KIRKLEES METROPOLITAN COUNCIL INVESTMENT & REGENERATION SERVICE

DELEGATED DECISION TO DETERMINE APPLICATIONS FOR CONSENT, AGREEMENT OR APPROVAL REQUIRED BY CONDITION

Reference No:	2026/44/90240/W
Site Address:	Huddersfield Bus Station, Upperhead Row, Huddersfield, HD1 2JN
Description:	Discharge of details reserved by conditions 12 (phase 1 surface water management), 17 (external plant or machinery), 31 (phase 1 bus disruption plan) and 32 (phase 1 foundation proximity to railway) on previous permission 2025/91604 for Variation condition 2 (plans) on previous permission 2024/92302 for refurbishment comprising (phase 1): facade improvements including Henry Street entrance; replacement shop fronts; alterations to external bus apron; extension and alterations to existing barrier within the bus alighting lane adjacent to Henry Street; (phase 2): new entrance canopy; public realm improvements; cycle hub; facade improvements including replacement shop fronts
Recommending Officer:	Liz Chippendale

DECISION – Discharge of Condition – Approve

Drawing No: HBS-BGH-Z0-XX-DR-C-0037 | Revision: P02  
Job No: 23-184 | Date: 10/10/25

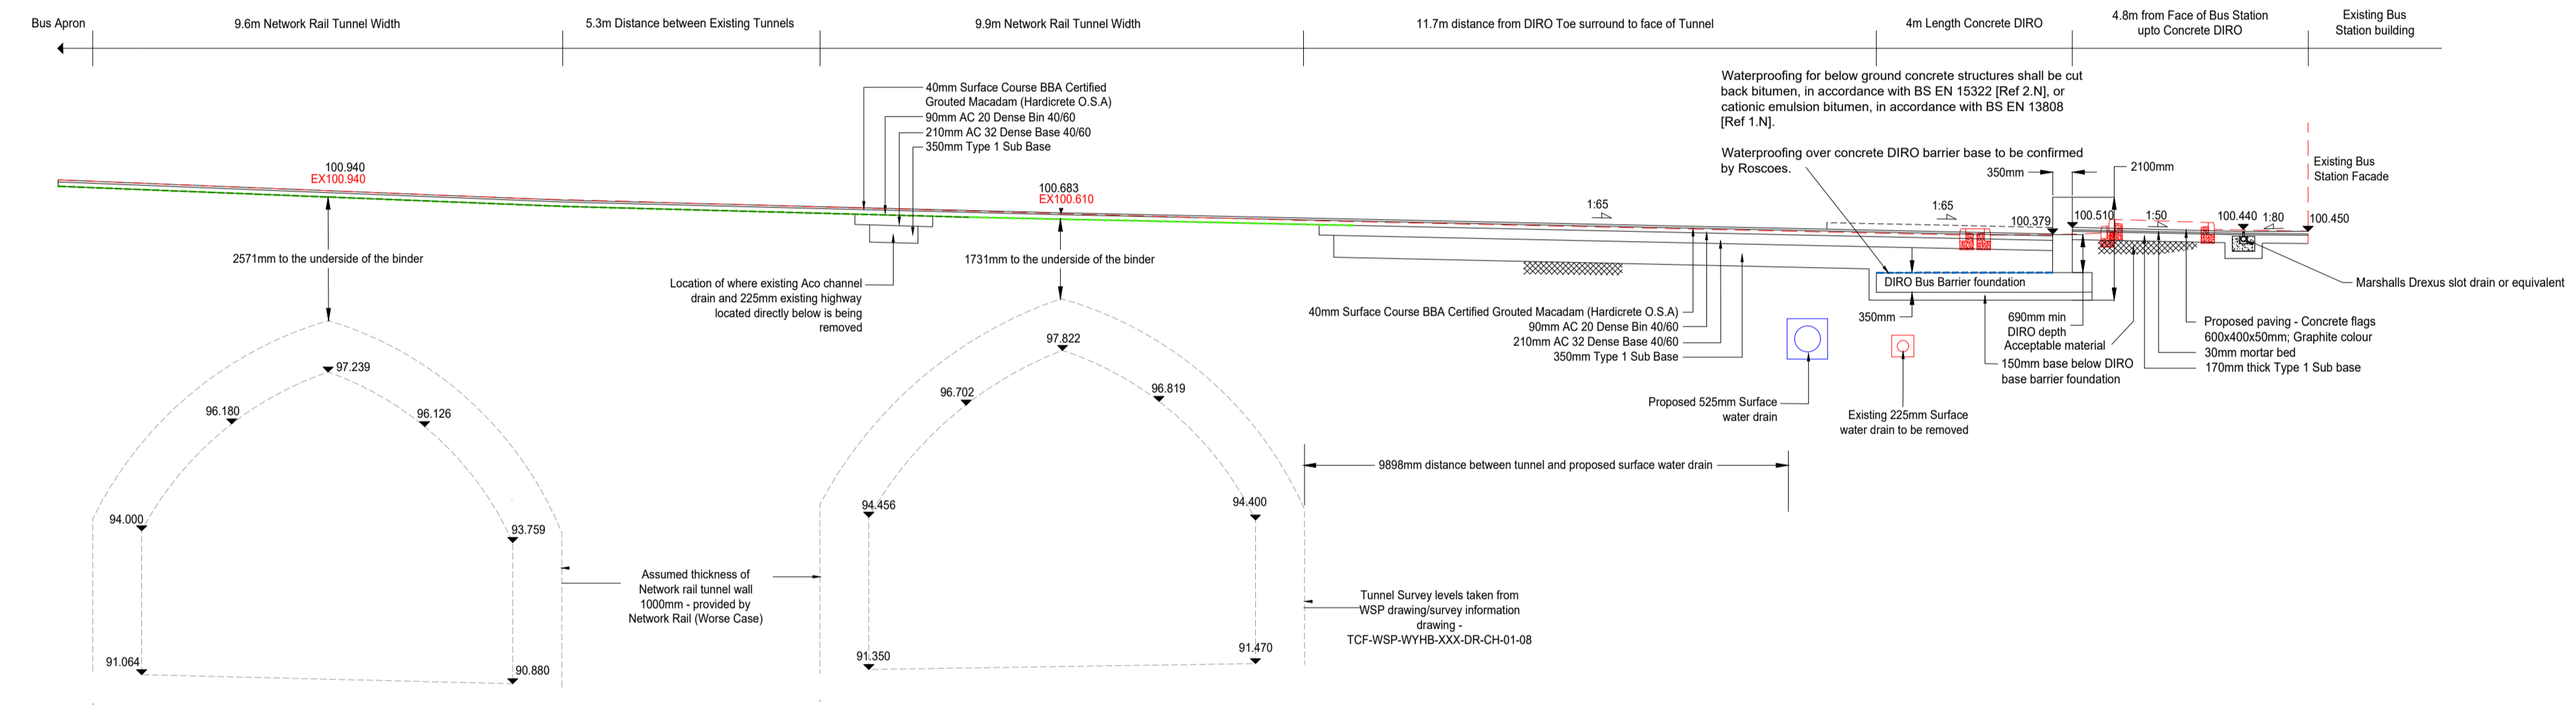
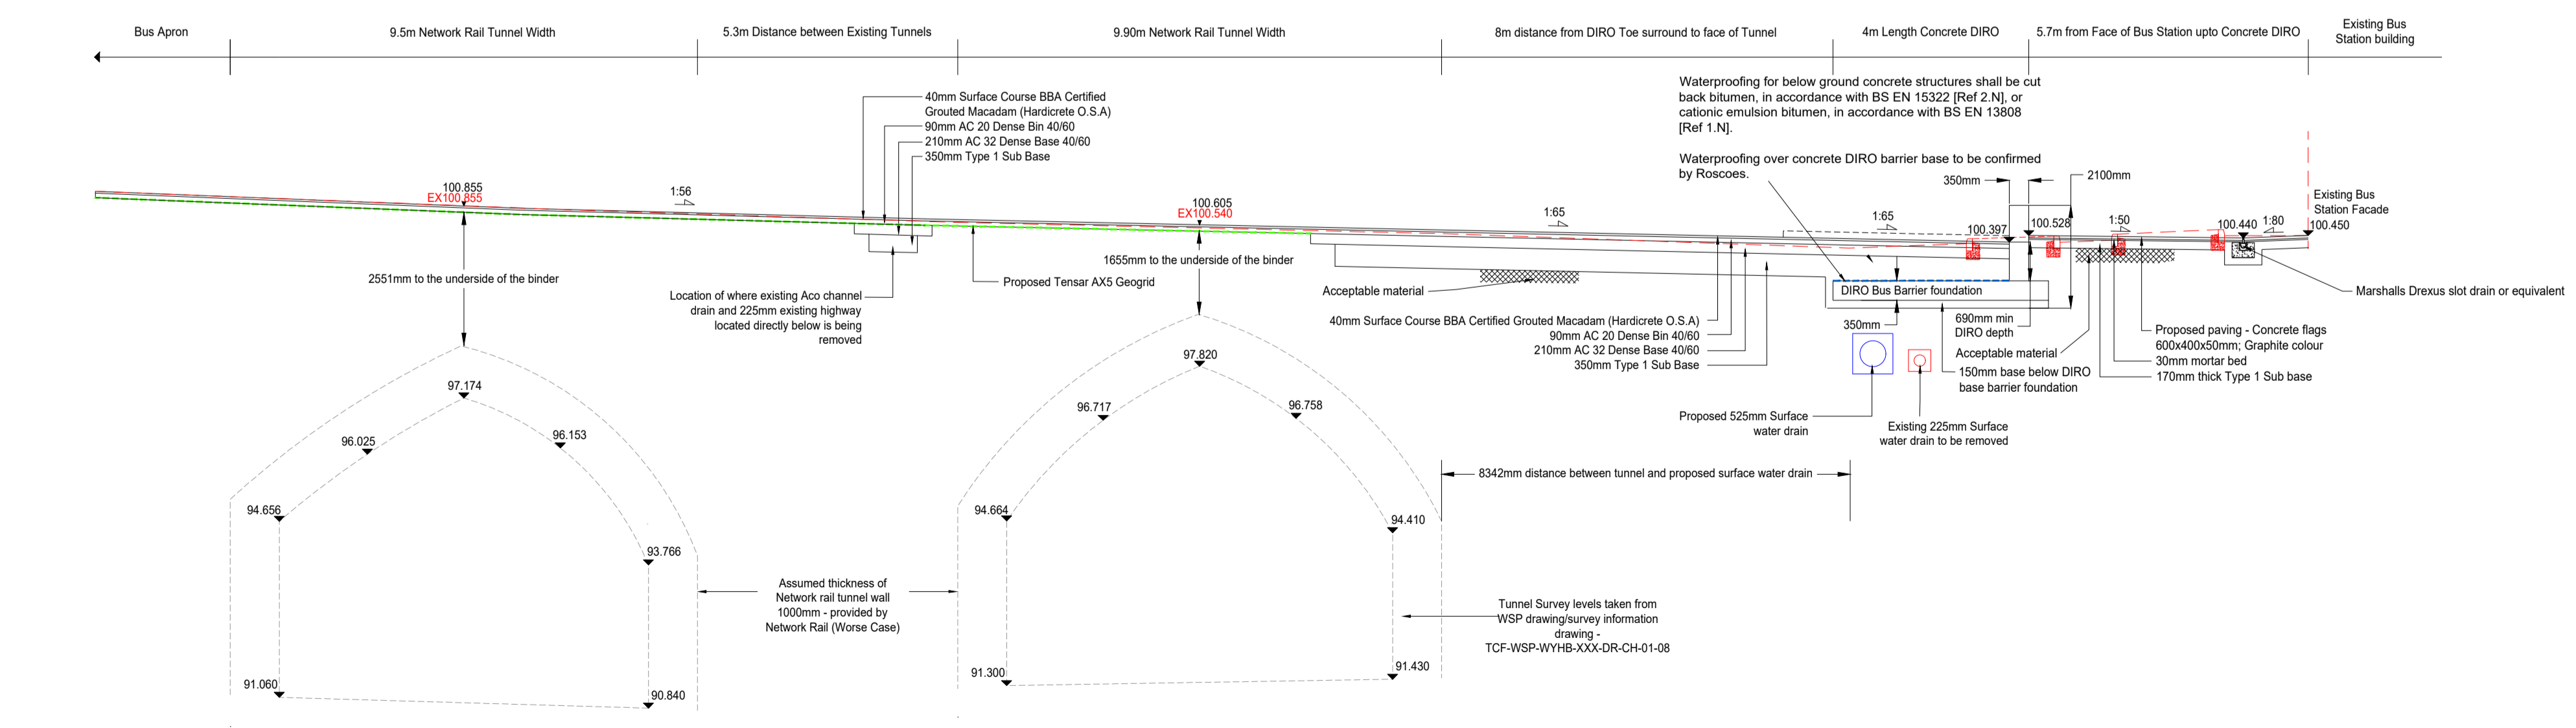
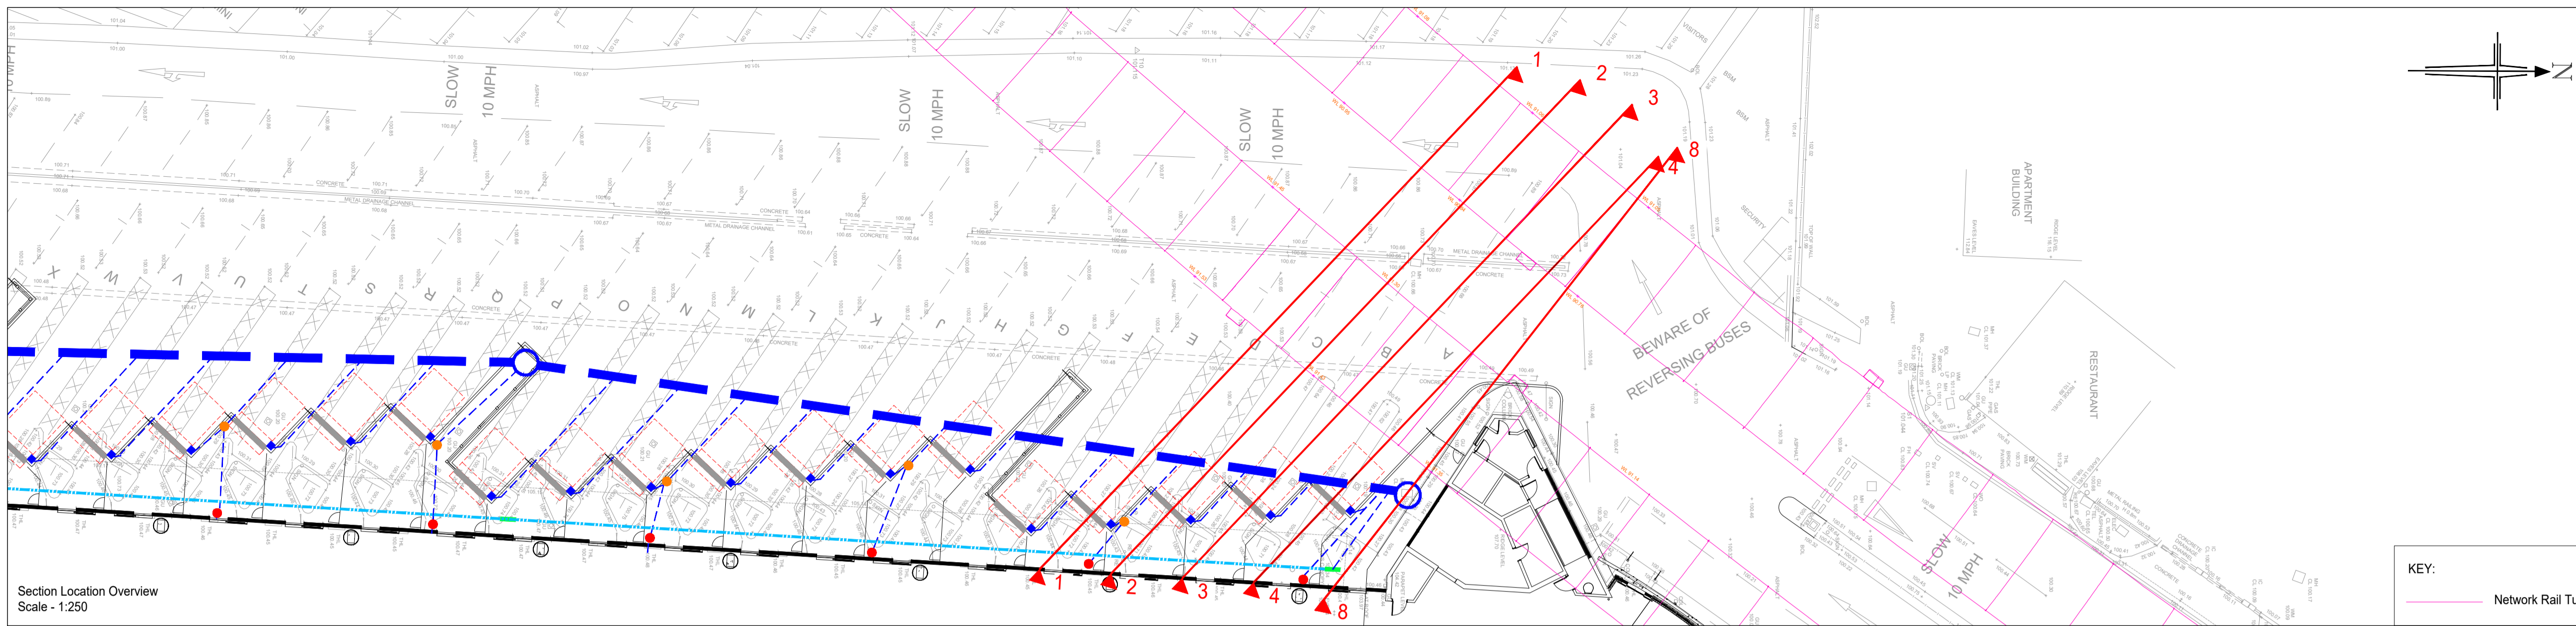
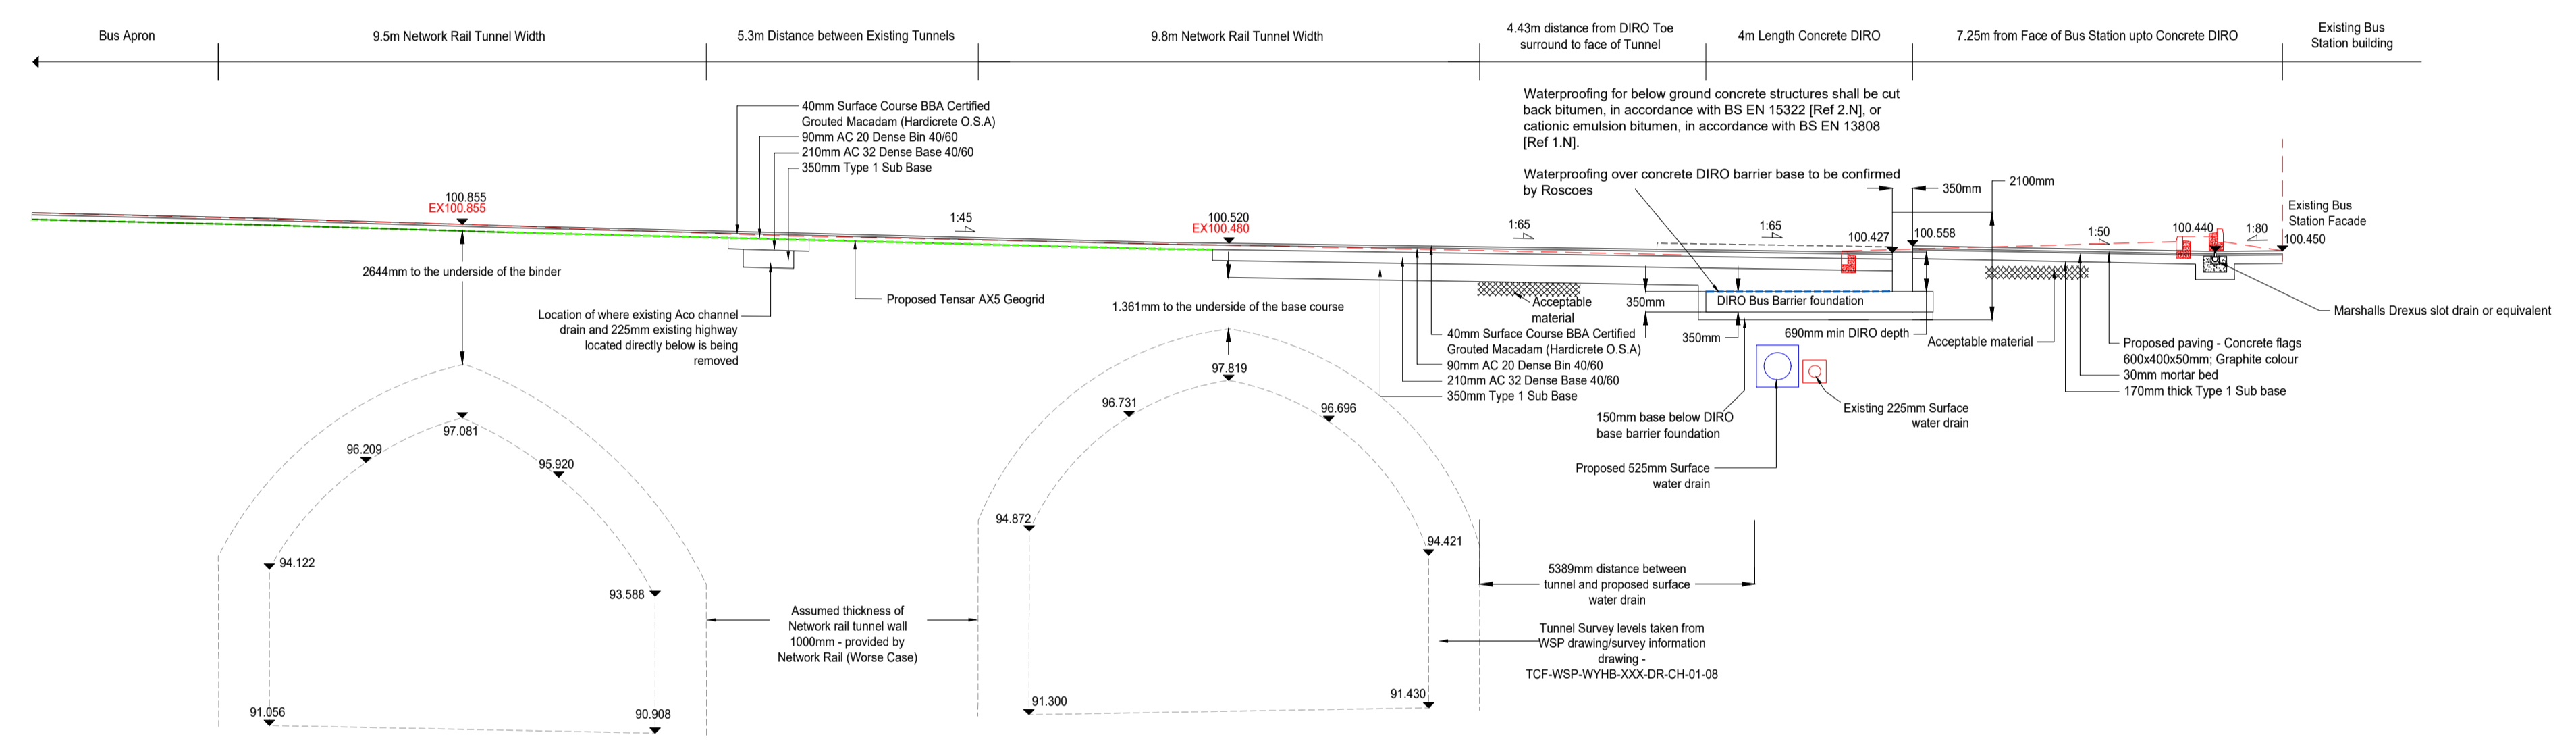
While we acknowledge that the proposed foundations, as detailed under condition 32, fall outside the tunnel's support zone, we would nonetheless recommend coordination with our Asset Protection Team. This engagement would ensure appropriate oversight and provide assurance that the works will not adversely affect the operational railway or associated infrastructure.

Officers concur with the comments and assessment made by Network Rail in that the details provided are sufficient for the requirements of condition 32 provided that the development is completed in accordance with the approved details.

Network Rail advise that the applicant coordinates with the Network Rail Asset Protection Team to ensure the appropriate oversight and provide assurance that the works will not adversely affect the operational railway or associated infrastructure.
